**Fountain Tracking Number # SP-26-006**

**Kroger Spoke – Site Development Plan | 702 Bandle Drive, Fountain, CO 80817**

**Please see below for responses to the plan review comments provided by your department. We have provided an itemized list of the comments with responses below it. Please refer to the attached drawings with revision clouds in response to the comments.**

C-406

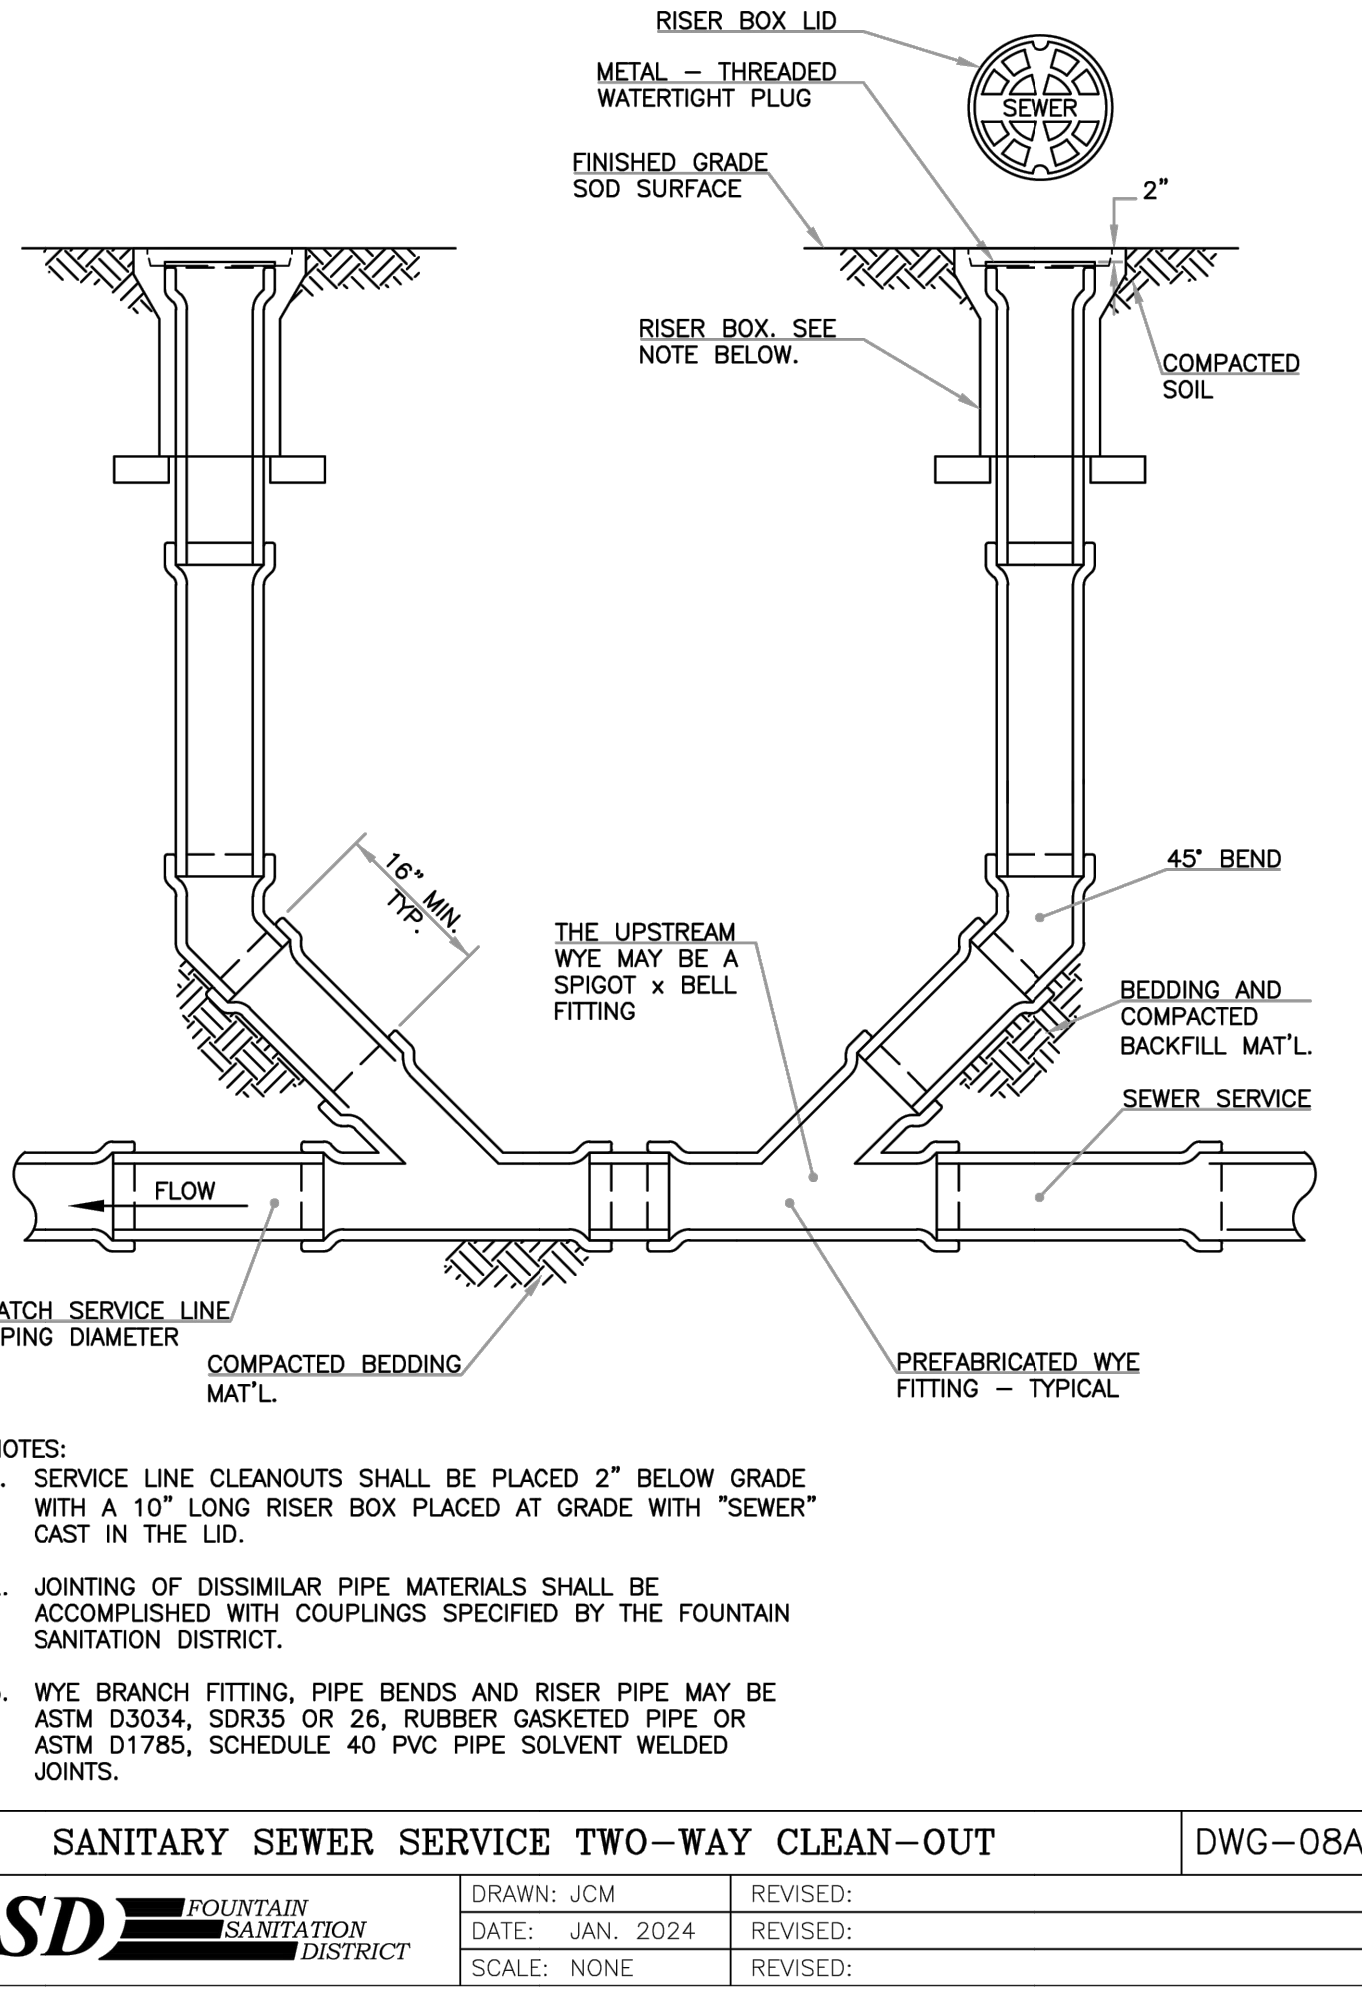
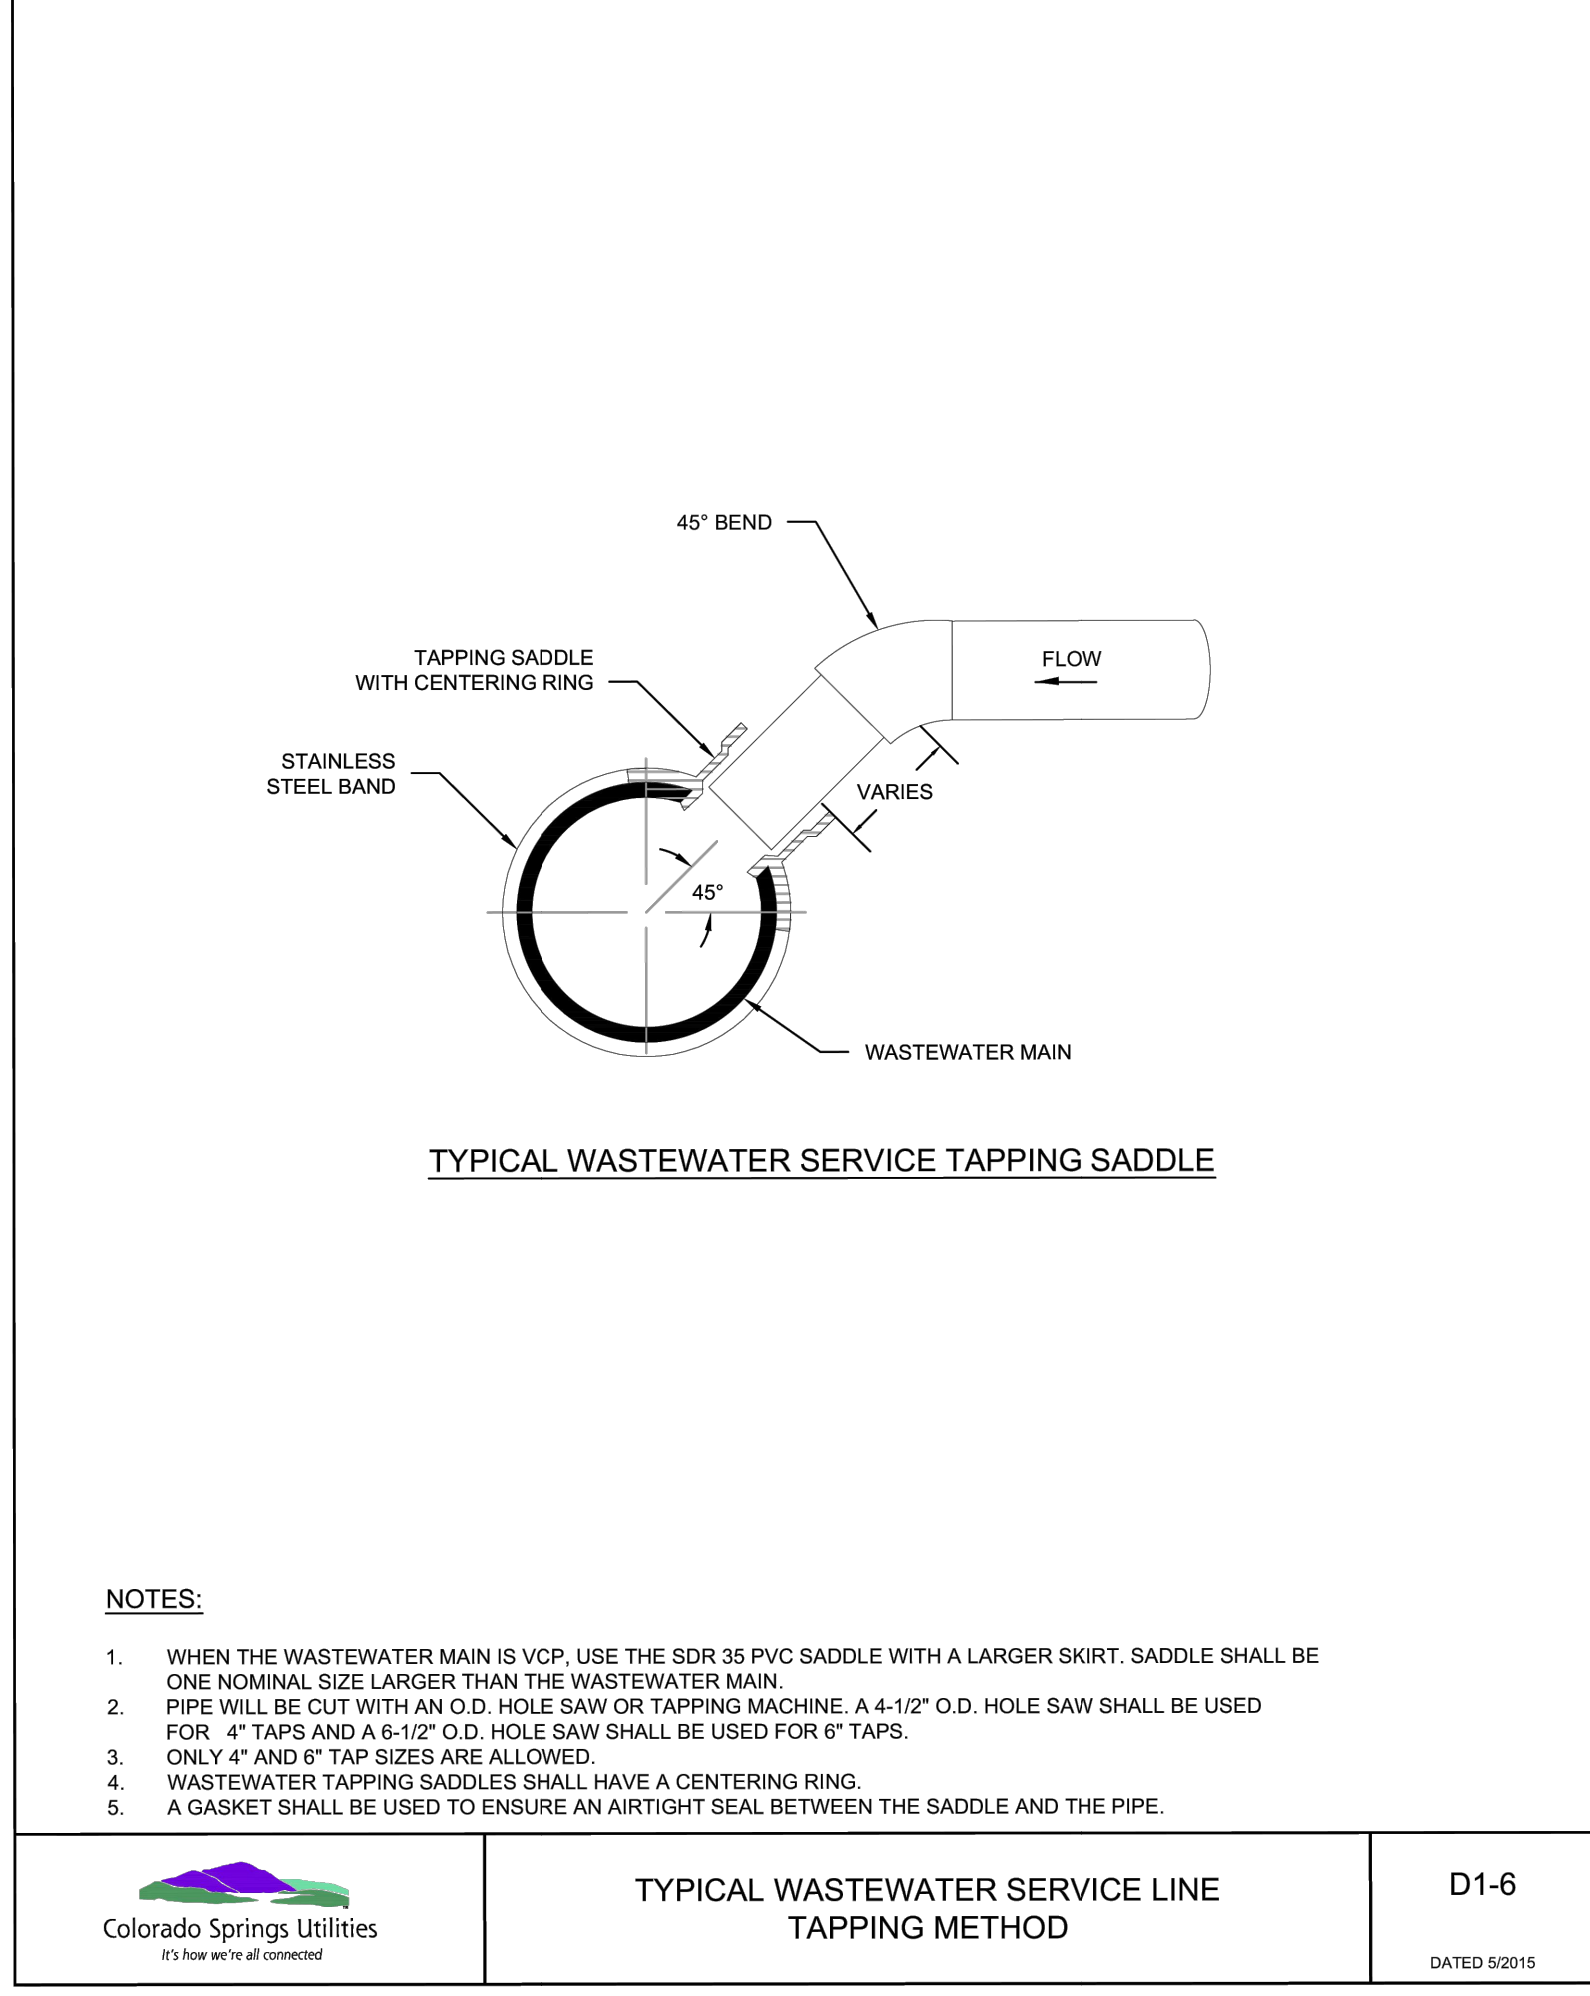
53. Callout B: (Page 26) C-406 Construction Details  
Change FSD detail to dwg-05.

**Response:** Detail has been updated
